Rezoning Petition Review – Charlotte Tree Ordinance

Subject: City of Charlotte – Urban Forestry Rezoning Petition Review Summary

Review Date: August 26, 2021

Rezoning Petition: 2021-089

SHEET NUMBER:  
**RZ1.0**

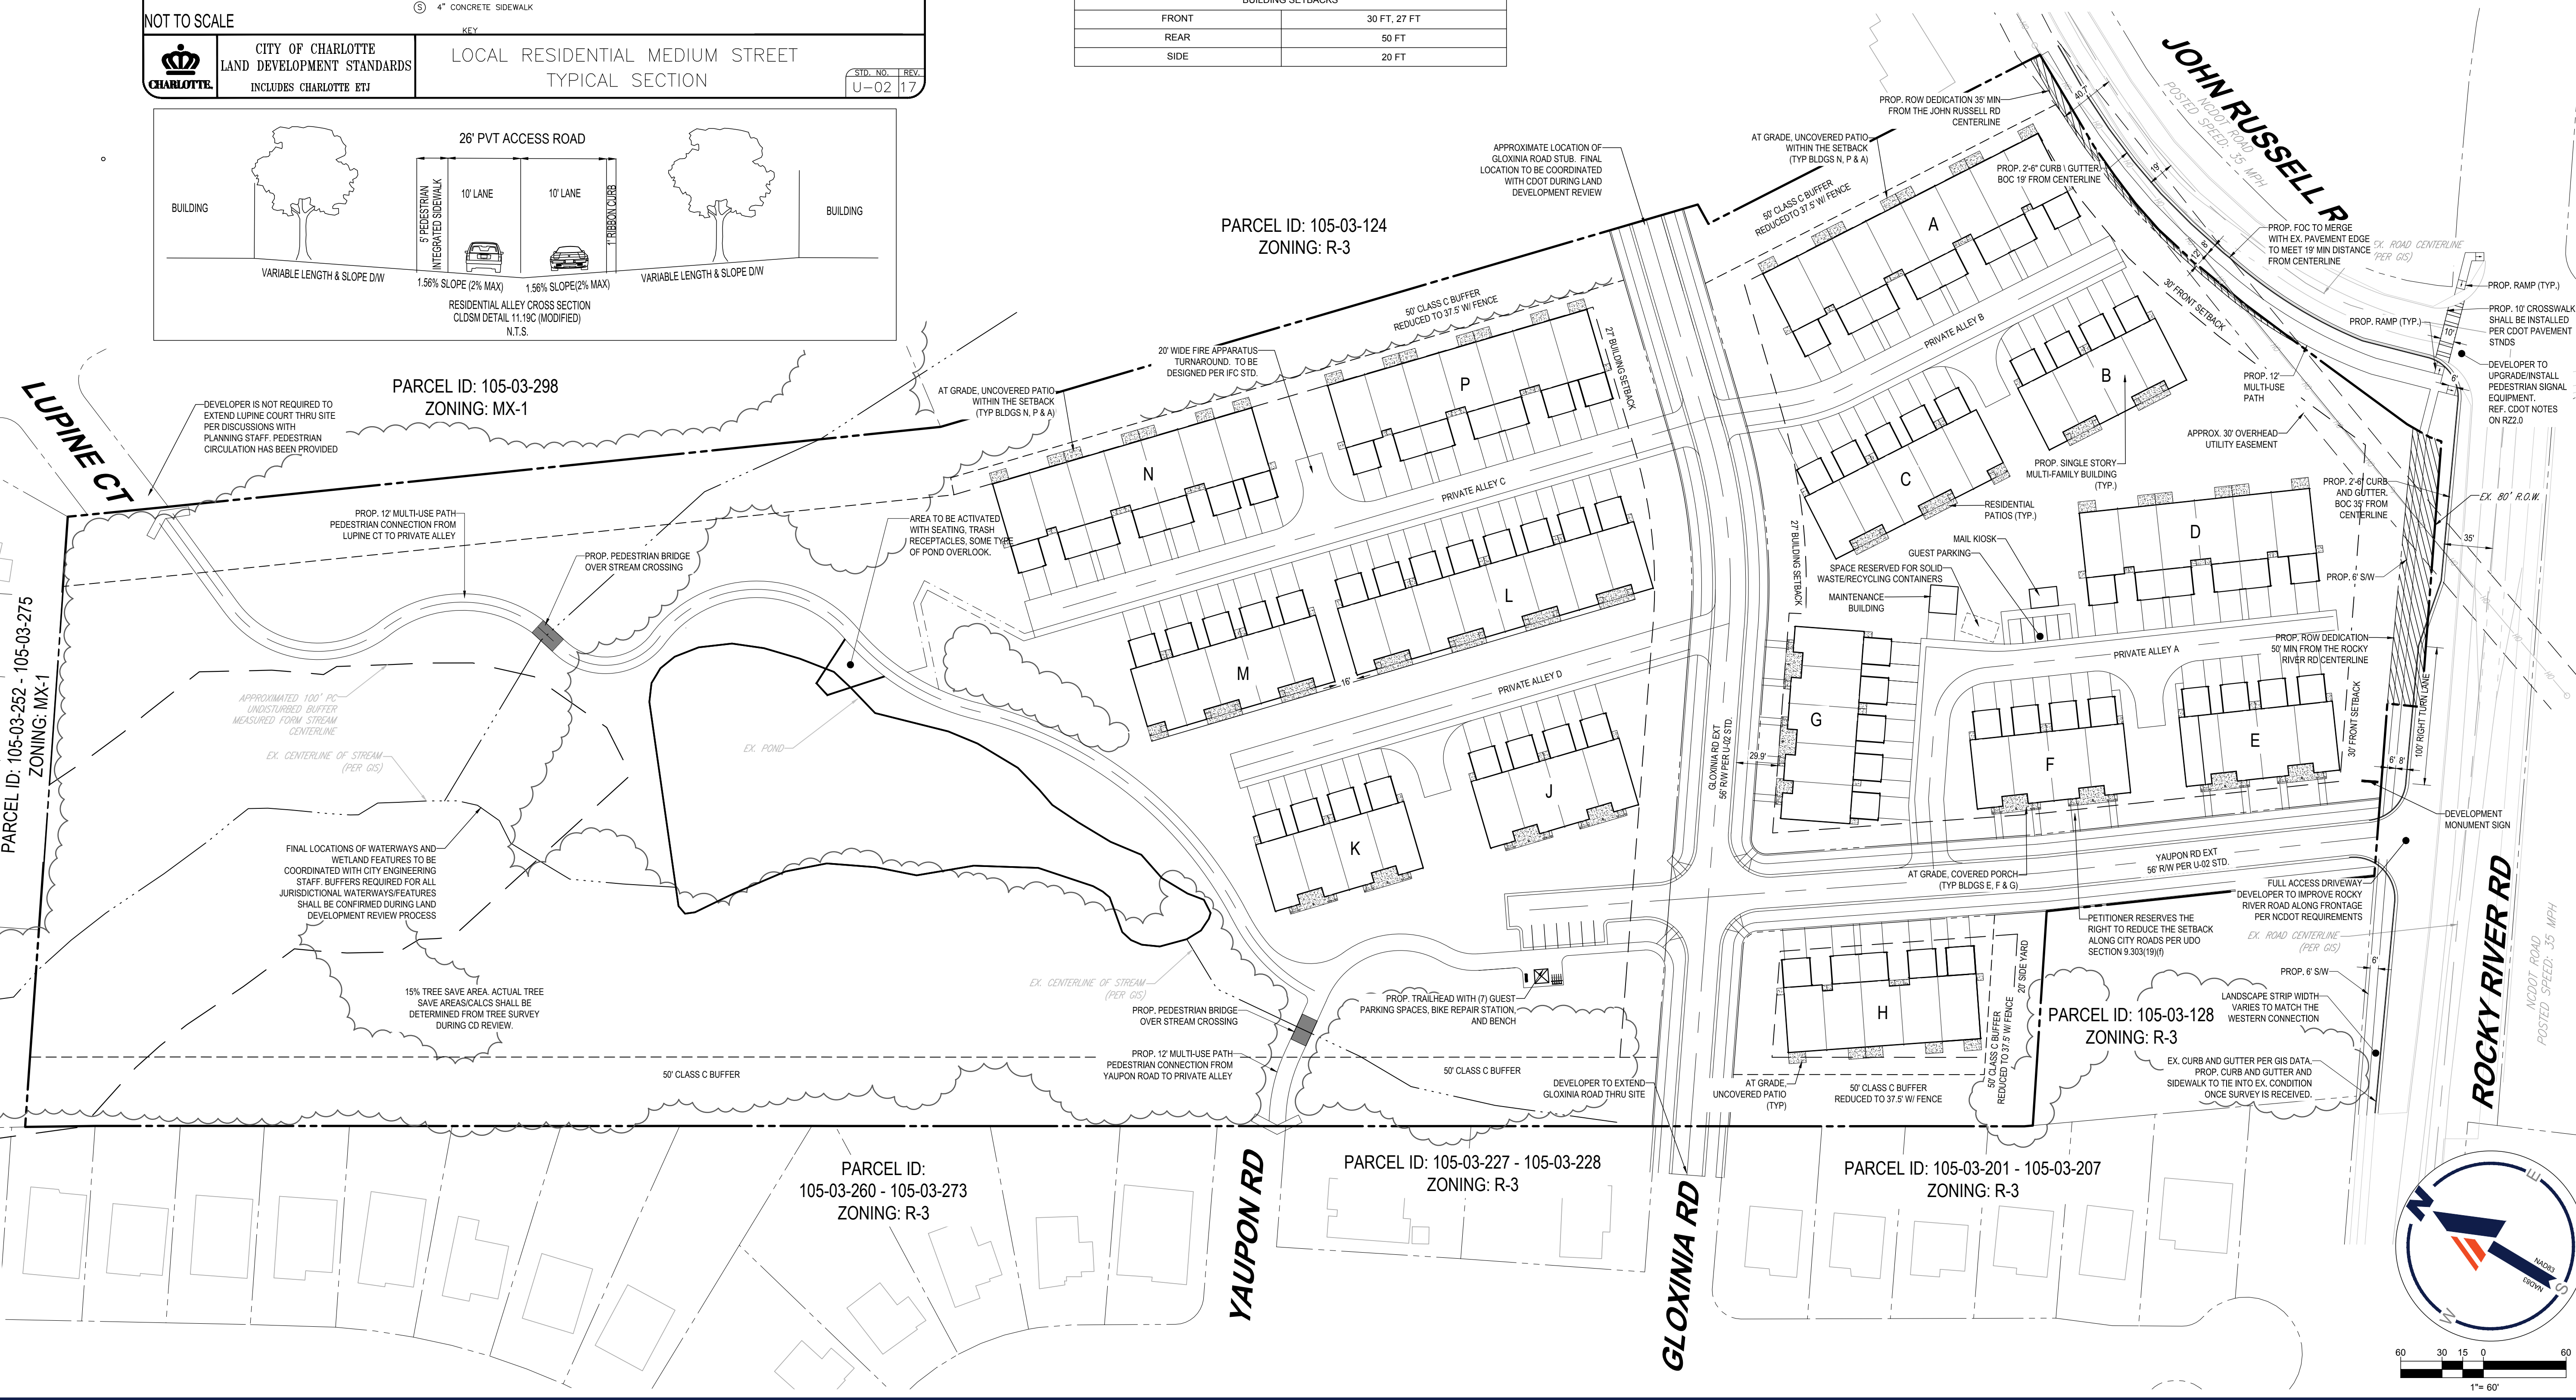
- A tree survey shall be submitted identifying all trees of eight-inch (8) dbh or greater and all planted trees of (2) two-inch caliper or greater and six feet in height that grow partially or wholly within public street right-of-way.

- Conditional rezoning petition submittals shall provide notation referencing how tree save requirements will be met by the site and depict potential tree save areas.

- Perimeter trees are required to be planted along all public roads per the Charlotte Tree Ordinance.
 - o Small-mature tree species are required in locations where overhead distribution lines may impact natural tree growth.
- Internal Trees: Internal trees may be required to be planted in all surface parking lots and to mitigate impacts from impervious surfaces on-site.
